ENG-SF22025-R4-CDs.pdf Markup Summary

Subject: Text Box
Page Index: 2
Date: 6/4/2024 4:58:23 PM
Author: eschoenheit
Color: █
Layer:
Space:
Page Label: [2] C2.2

EAGLE RISING FILING NO. 1
C2.2
 SHEET 2 OF 2

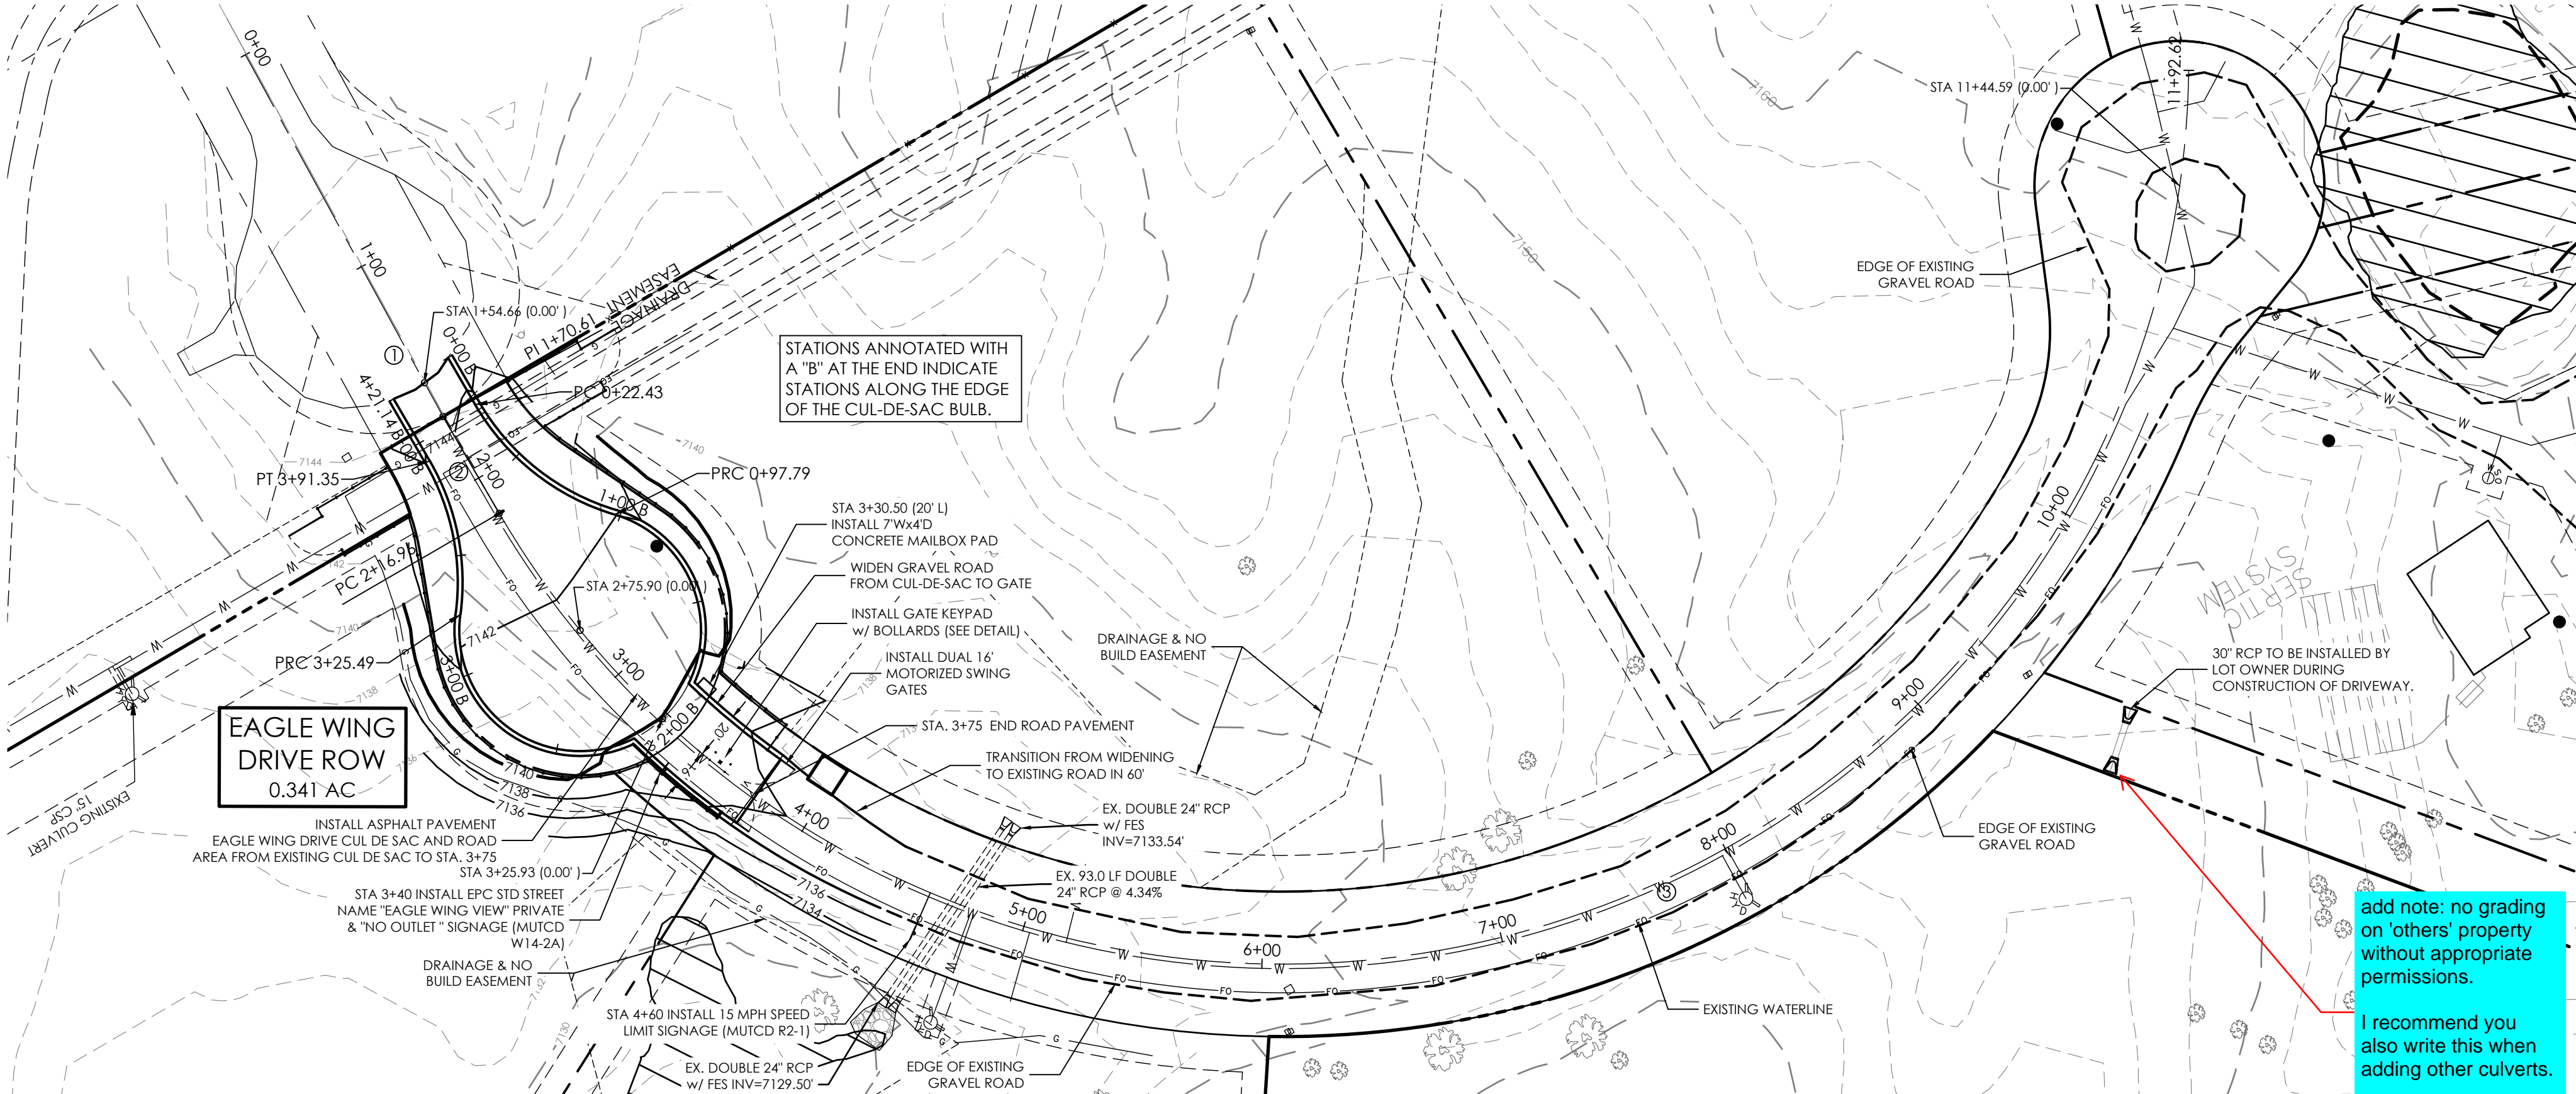
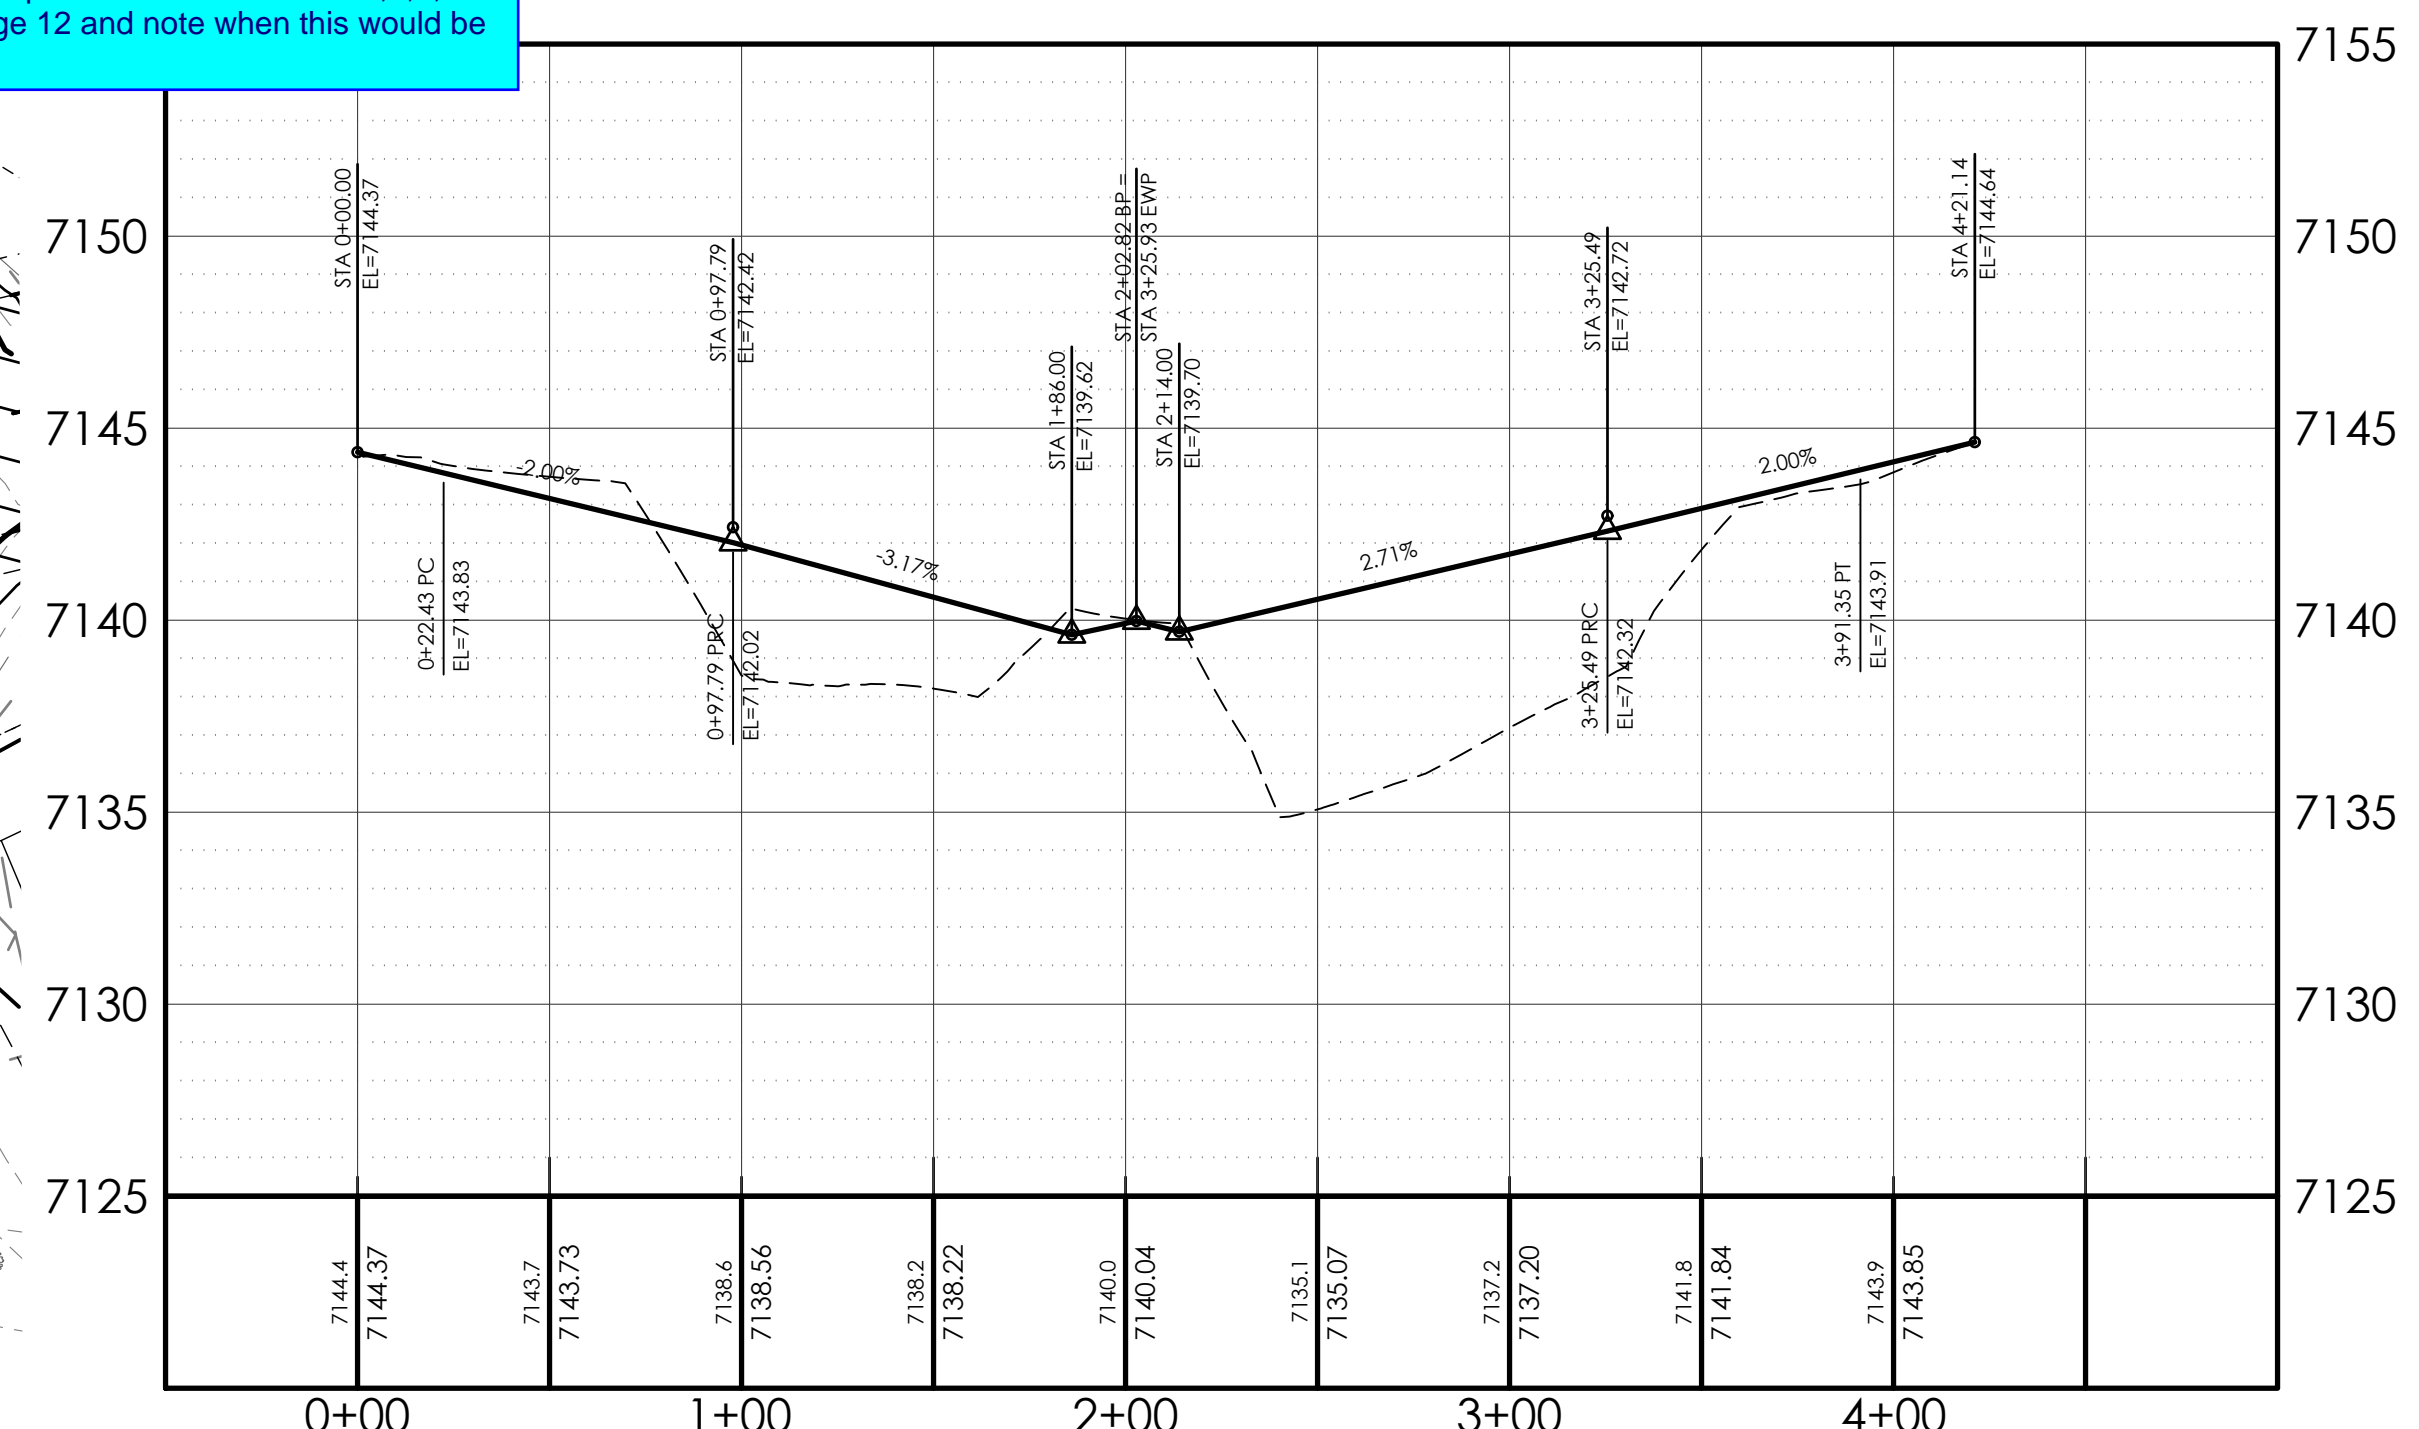
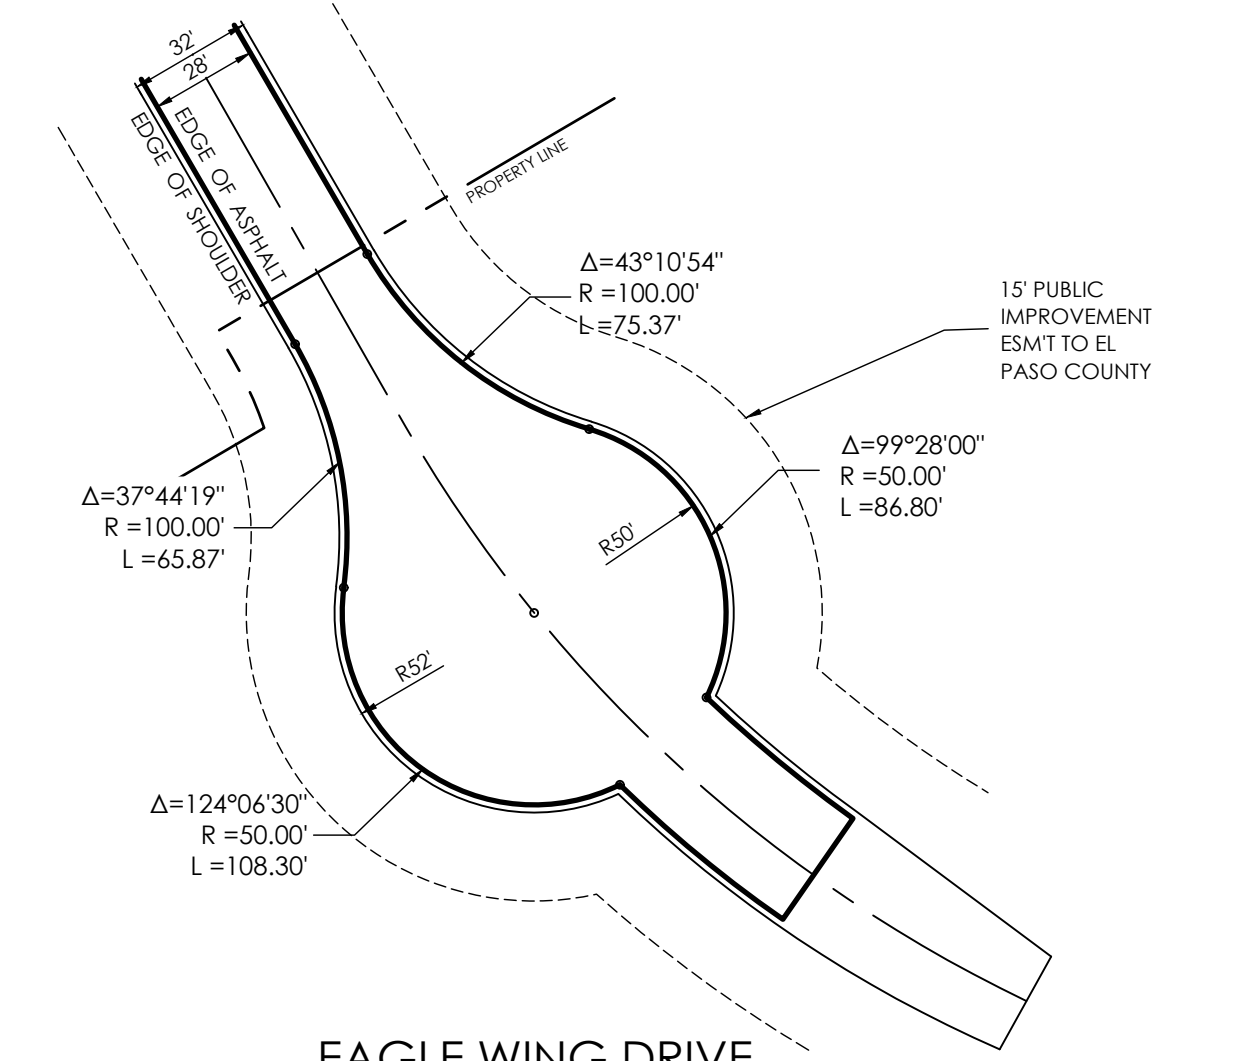
Please depict where the proposed culvert is for lots 3,4,5,6 as detailed in the FDR on page 12 and note when this would be installed.

please add: width of private drive shall be widened to 26' gravel at all locations. Depth of surface treatment shall be uniform and be a minimum of ___" thick (please insert the normal thickness of material out there. We can aid you in that if you like).

call out thickness

add note: no grading on 'others' property without appropriate permissions.

I recommend you also write this when adding other culverts.
